**From:** Roger Spencer  
**Sent:** 16 October 2017 13:48  
**To:** Planning.Responses  
**Cc:** Paul Cann  
**Subject:** RE: Planning Consultation on: P/107/17/PL

**APPLICATION NO:** P/107/17/PL

**Site Address:** Sefter Farm Pagham Road Pagham PO21 3PX

**Description of Works:** Extension of existing building

client	BARFOOTS OF BOTLEY LTD.		
project	Seffer Farm Packhouse 1 Corn Extension		
title	Proposed Block Plan

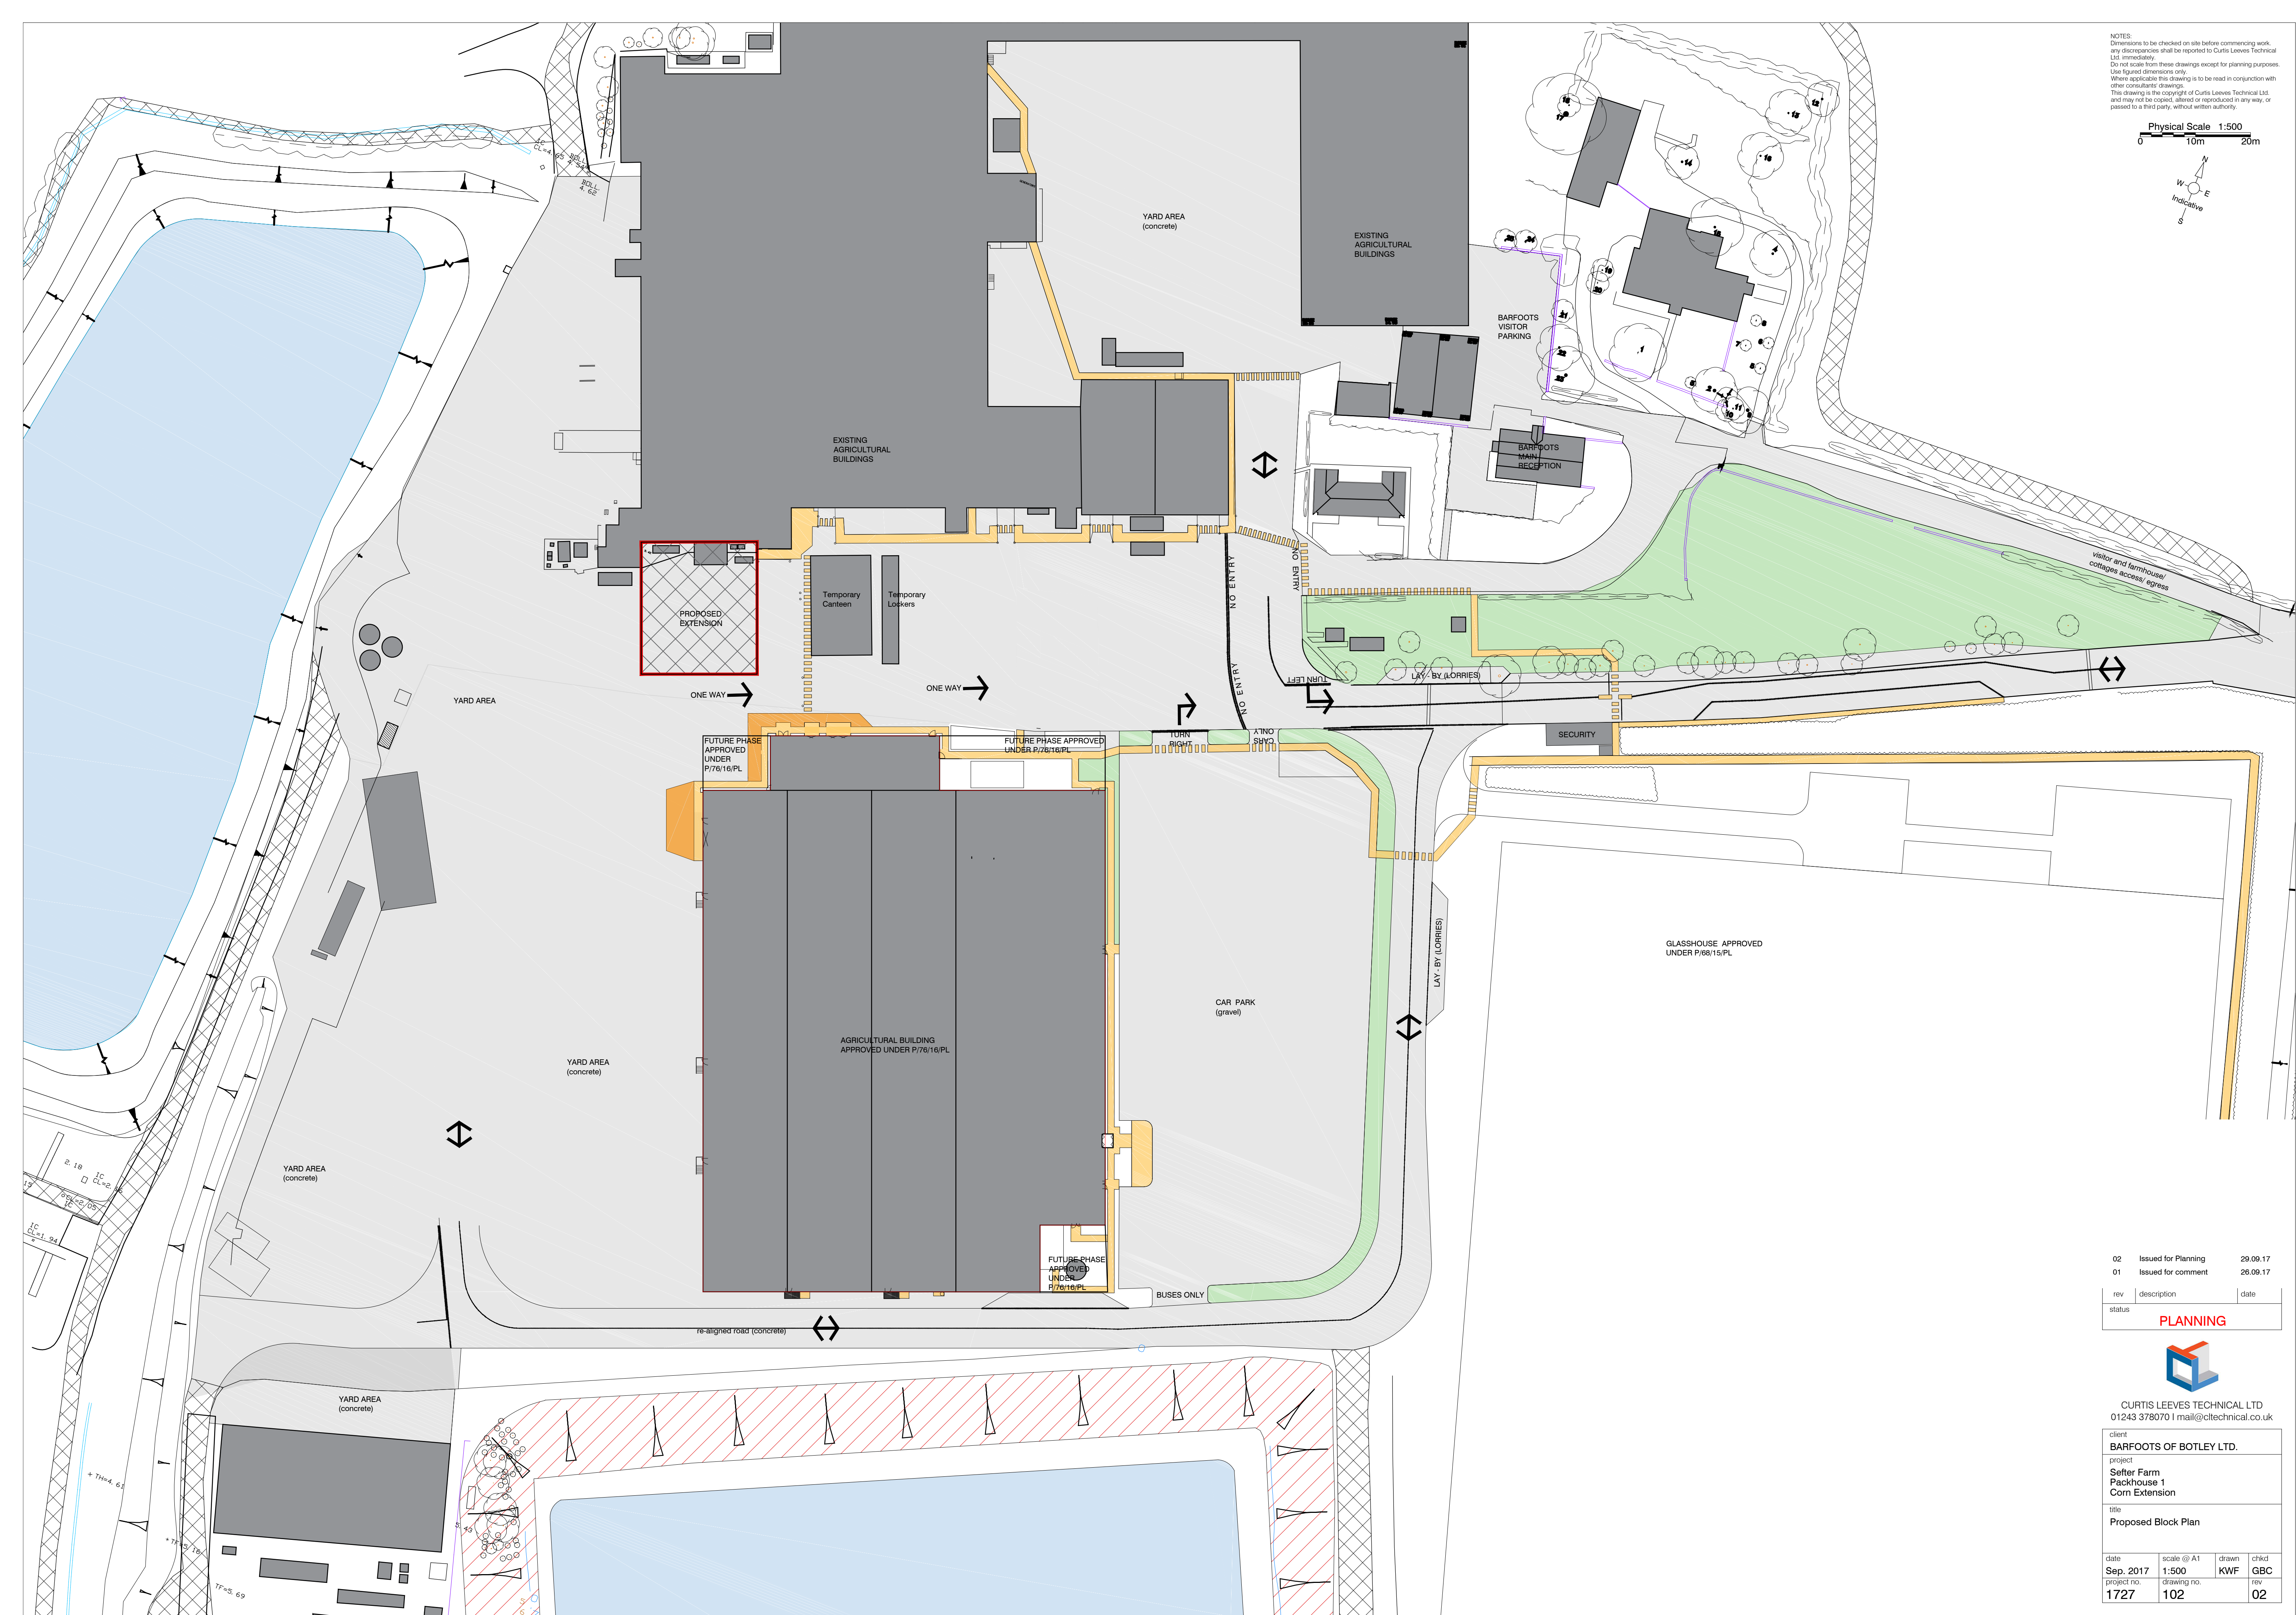
The Applicant advises that the extension will not form an appreciably larger impermeable area than as existing (due to the area currently forming a yard). This may, on the face of it, seem to be acceptable. However, whilst he does say that the drainage from the new development is to drain to a pond/lake, no details are given regarding how that yard is currently drained.

If the pond/lake in question has been specifically provided (previously) to take flows from the sheds etc. that are to be extended, (and they do not currently take the yard) it is not clear if the pond/lake has sufficient volume. If there is any overflow then that could find its way fairly directly into the flood-zoned area which is immediately adjacent to the reservoirs (pond/lake).

In summary, more detail on the existing and proposed run-off is required to show that the existing pond/lake is suitably sized.
